Regarding: An Coimisiún Pleanála - Case reference: VA16.324429

Development Description: Proposed 110kV electrical substation compound (~12,405 m²), 982 metres of 110kV underground cabling, 2 no. 16m end masts, a 36m telecommunications tower, temporary construction compound, access tracks, drainage network, tree felling, and ancillary works in the townland of Cloonbaul, Co. Mayo.

Re: Strategic Infrastructure Planning Application — Reference VA16.324429

TYPE A - ROAD SIDE SETTLEMENT POND DETAIL  
SCALE 1:100 (NOTE DIMENSIONS VARY DEPENDING ON CATCHMENT SIZE - SEE ATTACHED TABLE)

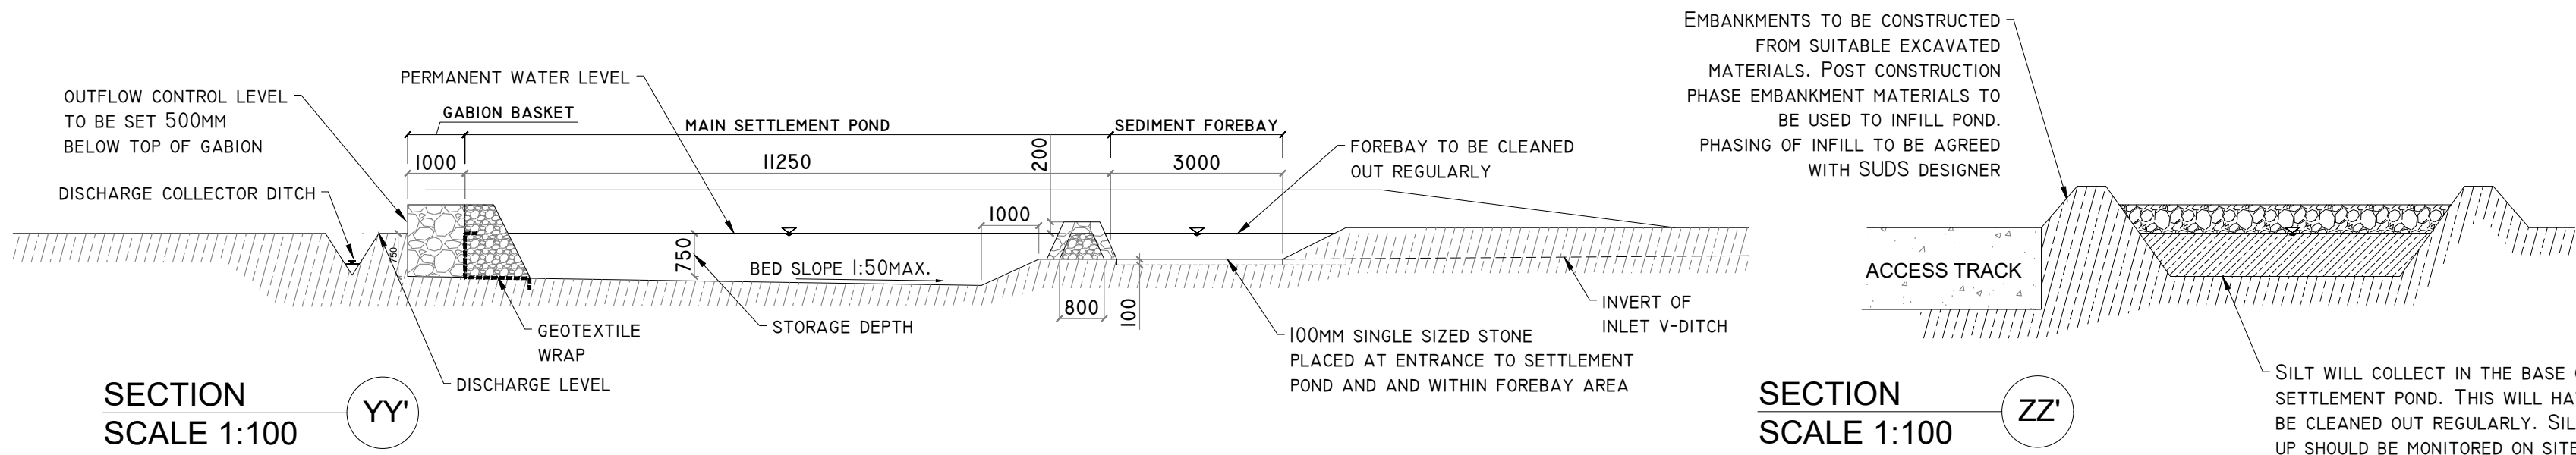
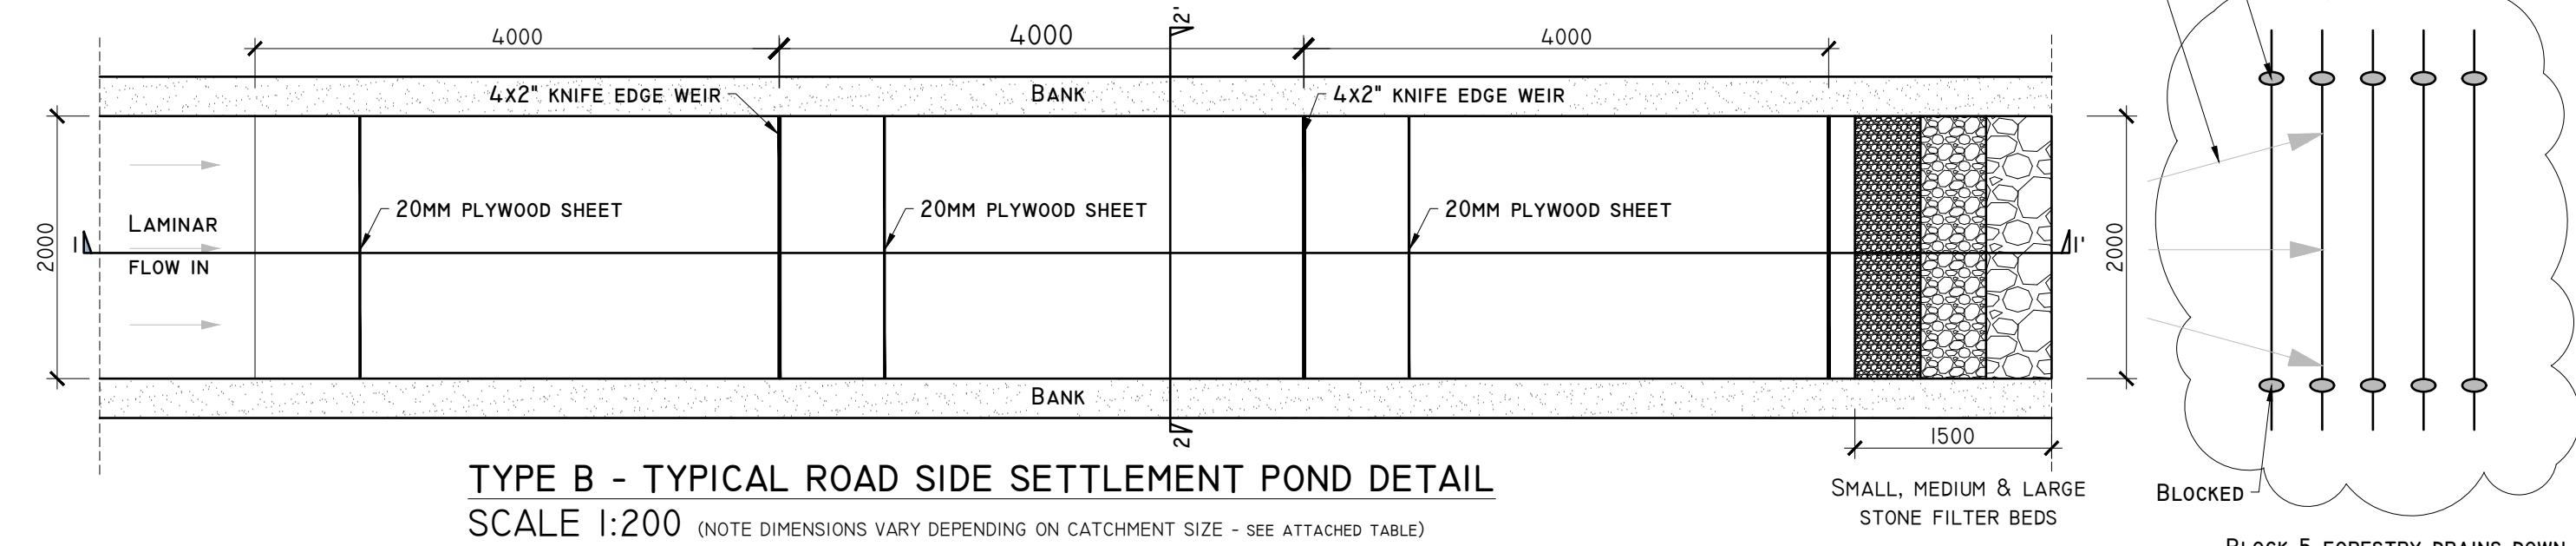
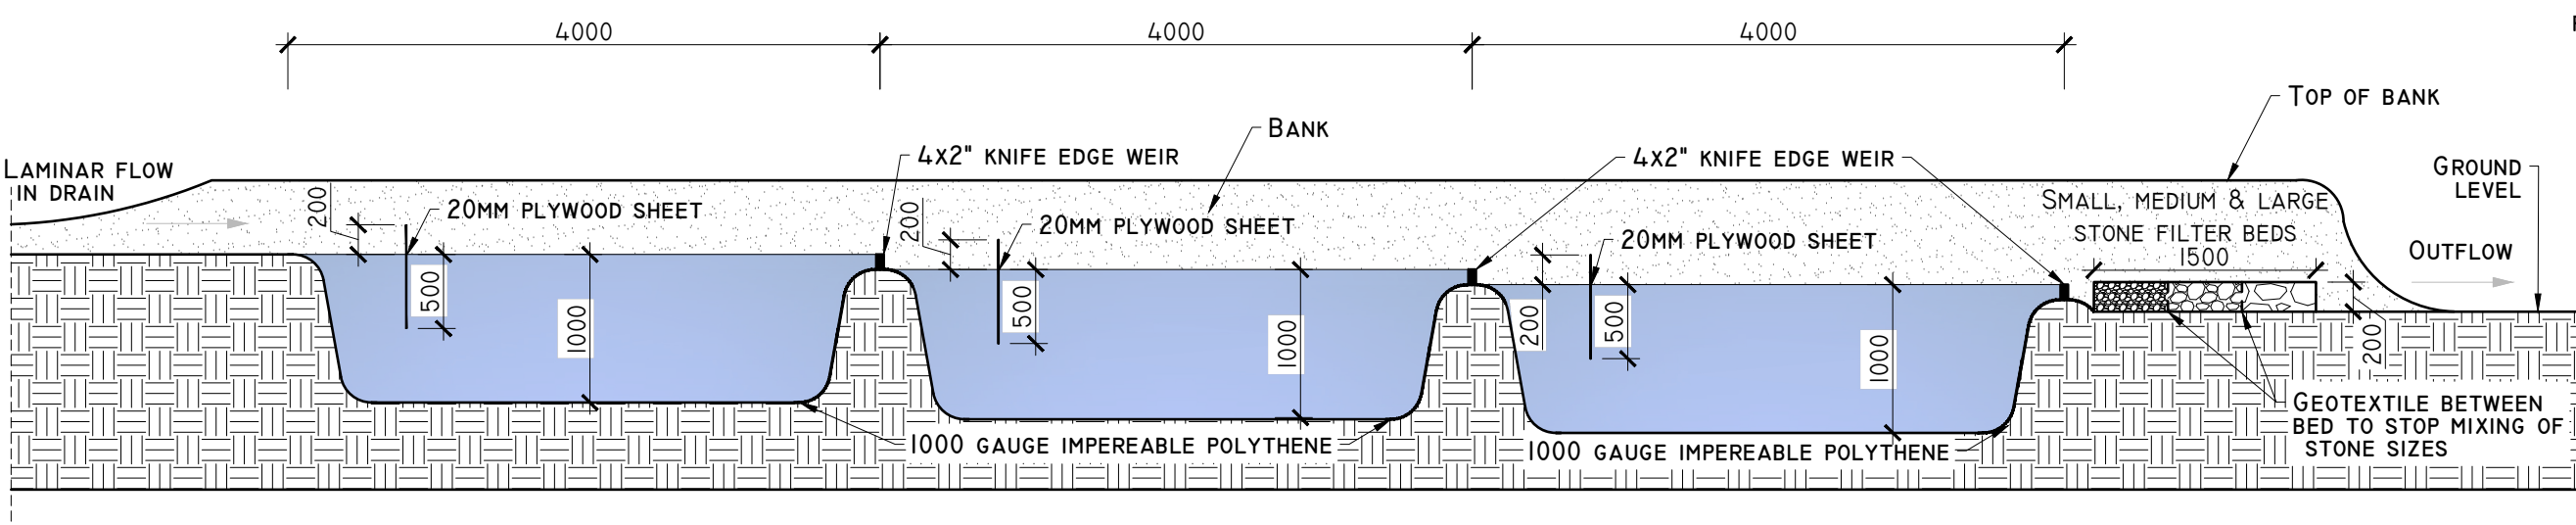
- **Failure to Provide Verifiable Volumetric Storage Capacities:** The applicant's layout plans indicate that surface water runoff from the 12,405 m² substation compound, temporary construction compound, 982m underground cable trenching routes, access tracks, and associated spoil management areas will be directed into a network of stilling ponds, swales, and settlement lagoons. However, the documentation fails to provide the exact technical specifications, physical dimensions, and cubic-metre storage capacities required for each individual attenuation structure, including defined top water levels. Without explicit metrics detailing the maximum physical volume these structures can contain before overtopping, the application relies entirely on qualitative assertions. It is mathematically impossible for An Coimisiún Pleanála to verify that these surface water controls are structurally adequate to achieve a true Greenfield Runoff Rate.

- **Failure to Demonstrate Safety Thresholds Against a 1-in-100-Year Storm Event:** Standard engineering specifications for Strategic Infrastructure Developments in Ireland (including CIRIA C753 The SuDS Manual guidelines) mandate that surface water systems must be designed to contain a 1-in-100-year storm event (a 1% Annual Exceedance Probability [AEP] event). The applicant has failed to provide explicit, localized hydrological modeling outputs demonstrating how the proposed attenuation network will perform under such extreme meteorological conditions across the townland of Cloonbaul. The ponds used in the submission are sized for a 1-in-10-year event and only appear aimed at reducing silt discharging to the environmentally sensitive area. There is no information confirming that there will not be adverse flooding issues associated with the addition of a large hardstanding area.

- **Total Absence of Climate Change Headroom Factoring:** In accordance with contemporary Irish planning and climate adaptation standards, surface water drainage models must incorporate a mandatory safety headroom allowance of 20% to 30% to account for projected increases in rainfall intensity. Because the applicant has failed to present transparent, quantified input/output data for a climate-factored 1-in-100-year storm event, the proposed drainage layout must be deemed structurally undersized.

- **Saturation Capacity Failure & Downstream Vulnerability:** Because the applicant has failed to prove that the proposed settlement ponds and attenuation structures possess the physical storage capacity to choke back peak storm surges, the civil works will inevitably result in increased, severe flash flooding downstream, endangering the residential structures and commercial curtilage at Eircode F12 XW61.
